Application for Removal or Variation of a Condition following Grant of Planning Permission or Listed Building Consent

Erection of two storey wraparound side and rear extension

29504/APP/2025/2818

PROPOSED REAR (SOUTH) ELEVATION

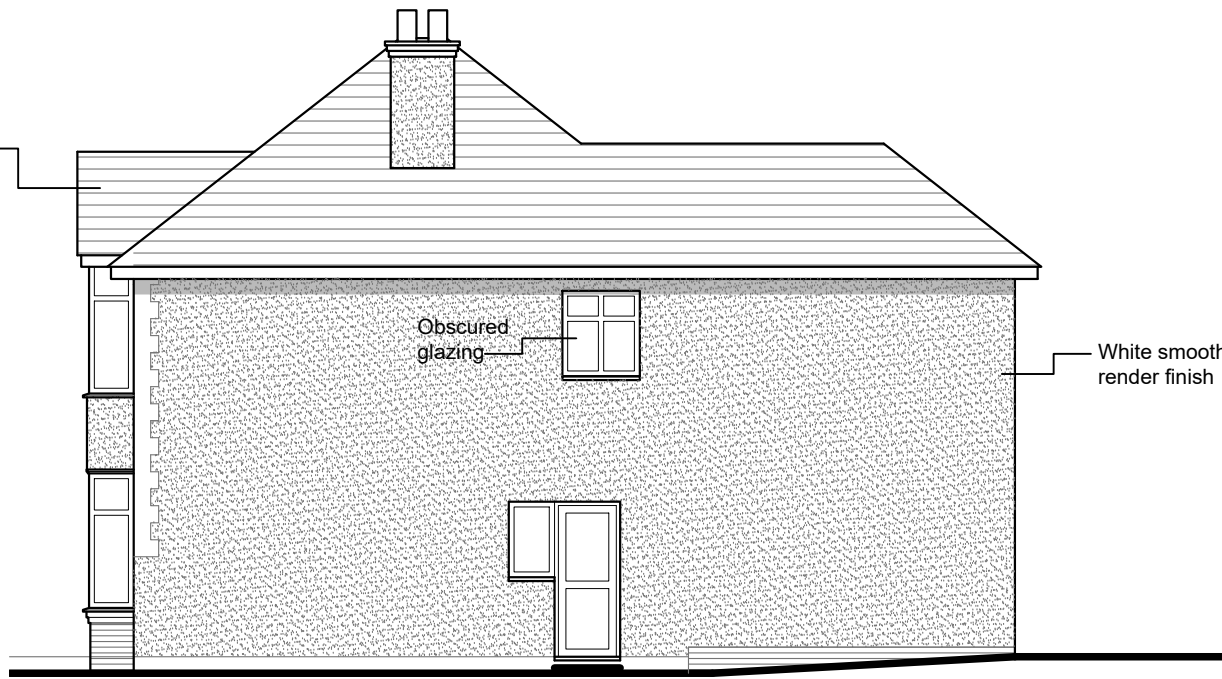
Insertion of Juliette balconies on rear elevation in lieu of windows

Drawing number 25/15MR(P)02 to be replaced with 25/15MR(C)02B
